Recommendation Report for Planning Permission for Works or Extension to a Dwelling

REF NO: EP/55/20/HH

LOCATION: 49 Somerset Road
East Preston
BN16 1BY

PROPOSAL: Single storey rear extension.

Rev	Notes	Date
 23 Mill Road Angmering, West Sussex BN16 4HT E:natdesign1@gmail.com		
Project: 49 Somerset Road, East Preston West Sussex, BN16 1BY		
Drawing Proposed Elevations		
Drawn By: NSE		Scale: as shown @ A3
Date: May 2020		Revision:
Drawing No. 648 - DPA 05

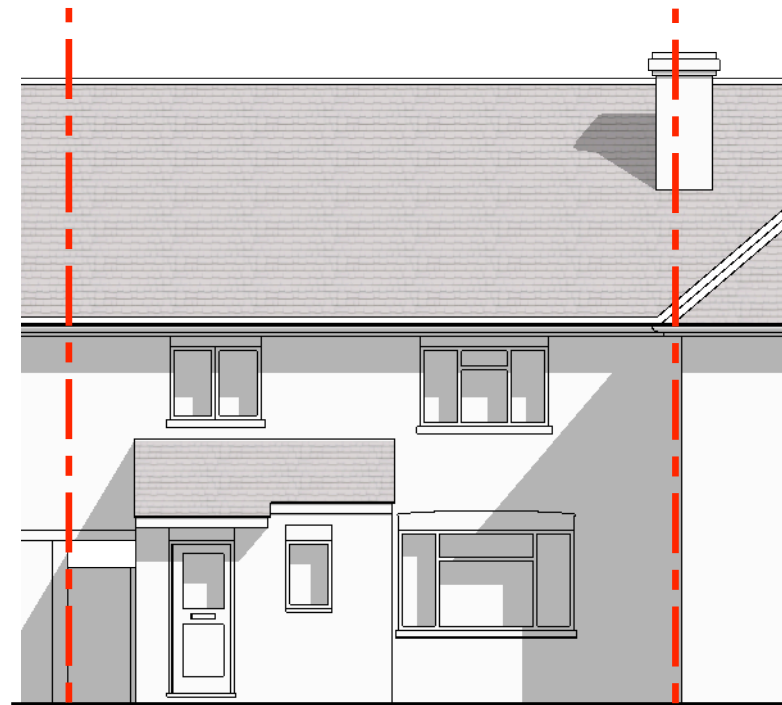
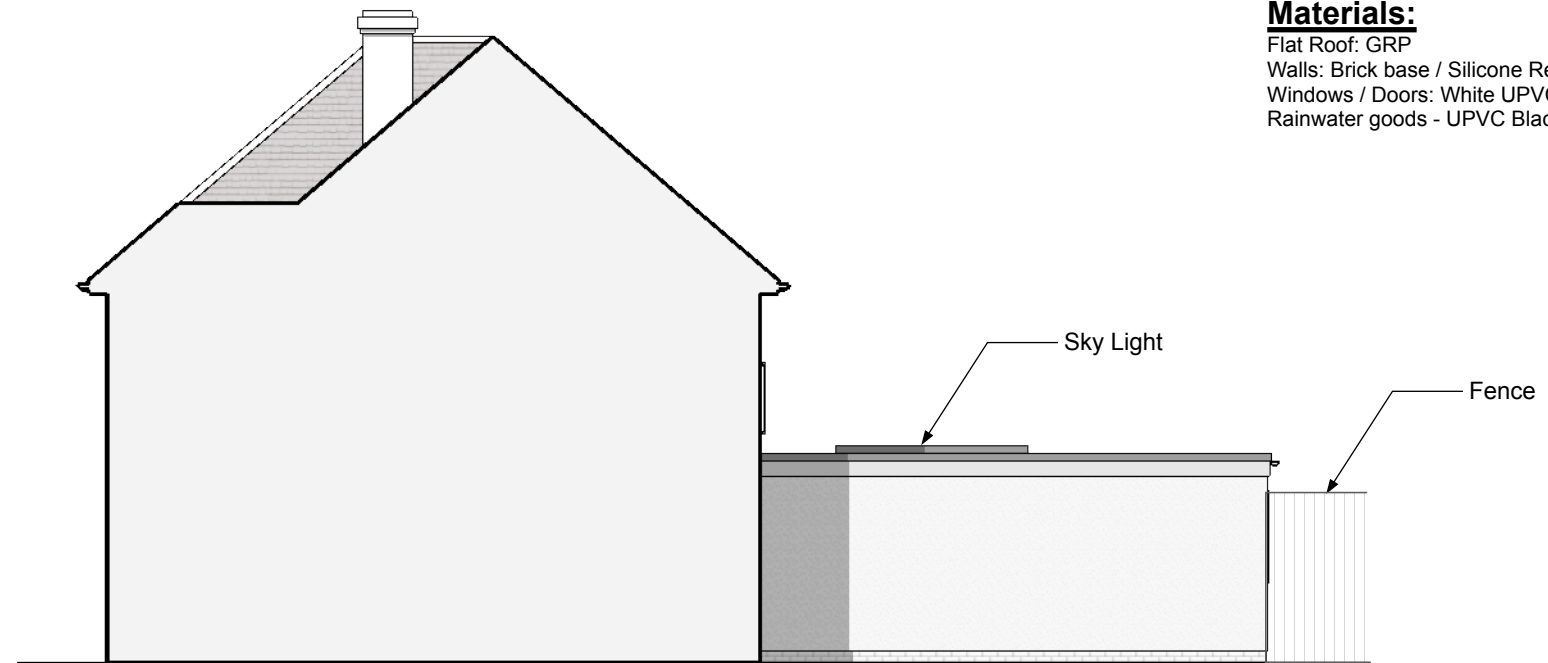
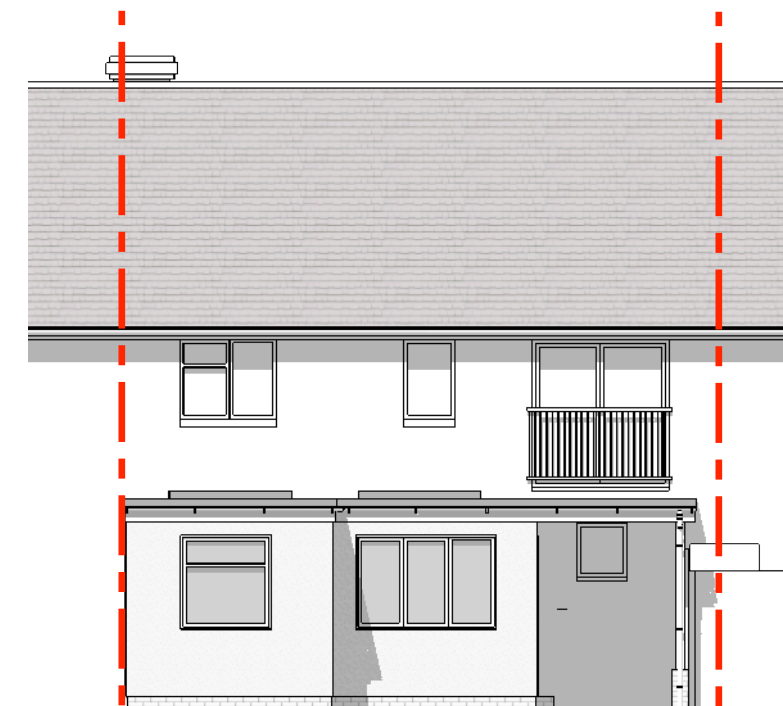
The proposed development is not considered to result in any significantly harmful overshadowing or overbearing impact upon the occupiers of neighbouring dwellings. The built form is a replacement for existing built form with the only difference being an additional 30 cm in height at a total height of 2.81 metres. This is not considered to create additional loss of light or overbearing impact such that a refusal of the application would be warranted.

There are no windows in the extension which would overlook the neighbouring properties.

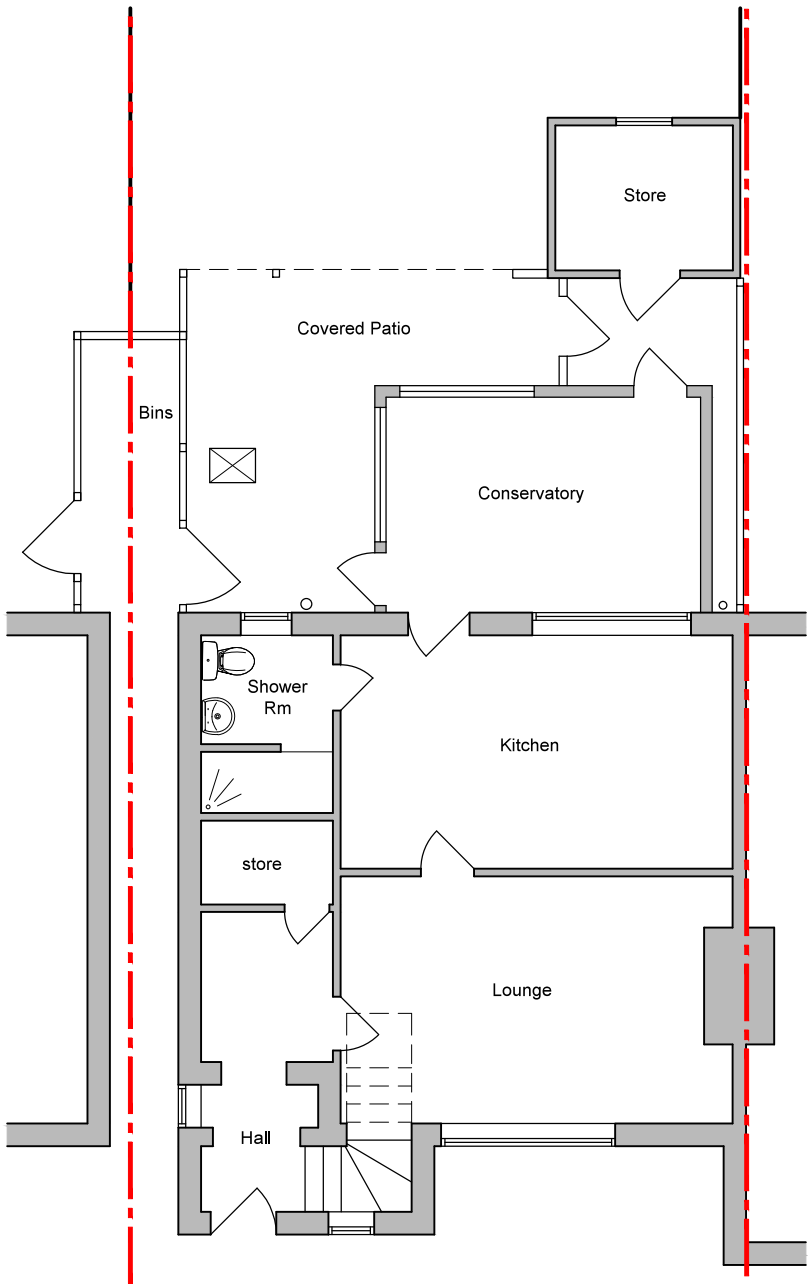
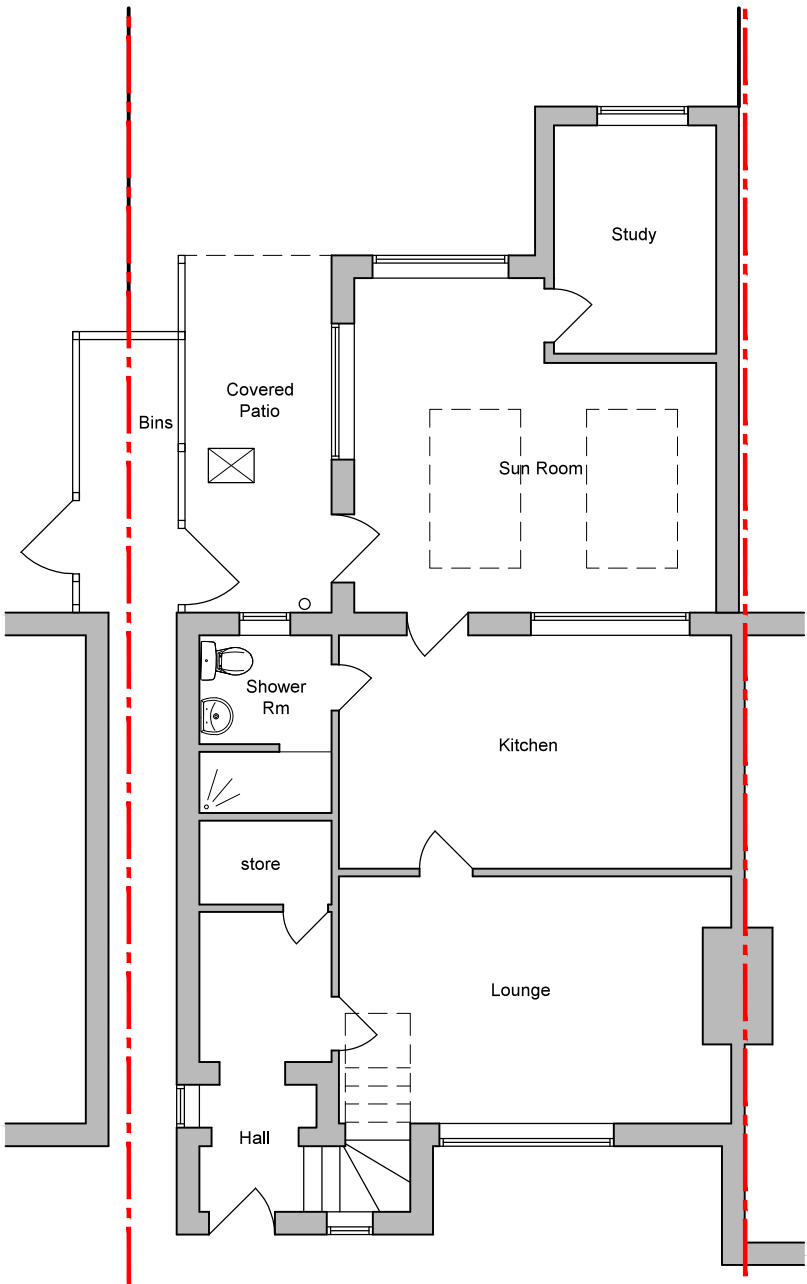
DESCRIPTION OF APPLICATION The proposal is to replace an existing conservatory and store room at ground floor level at the rear of the property with a sun room and study
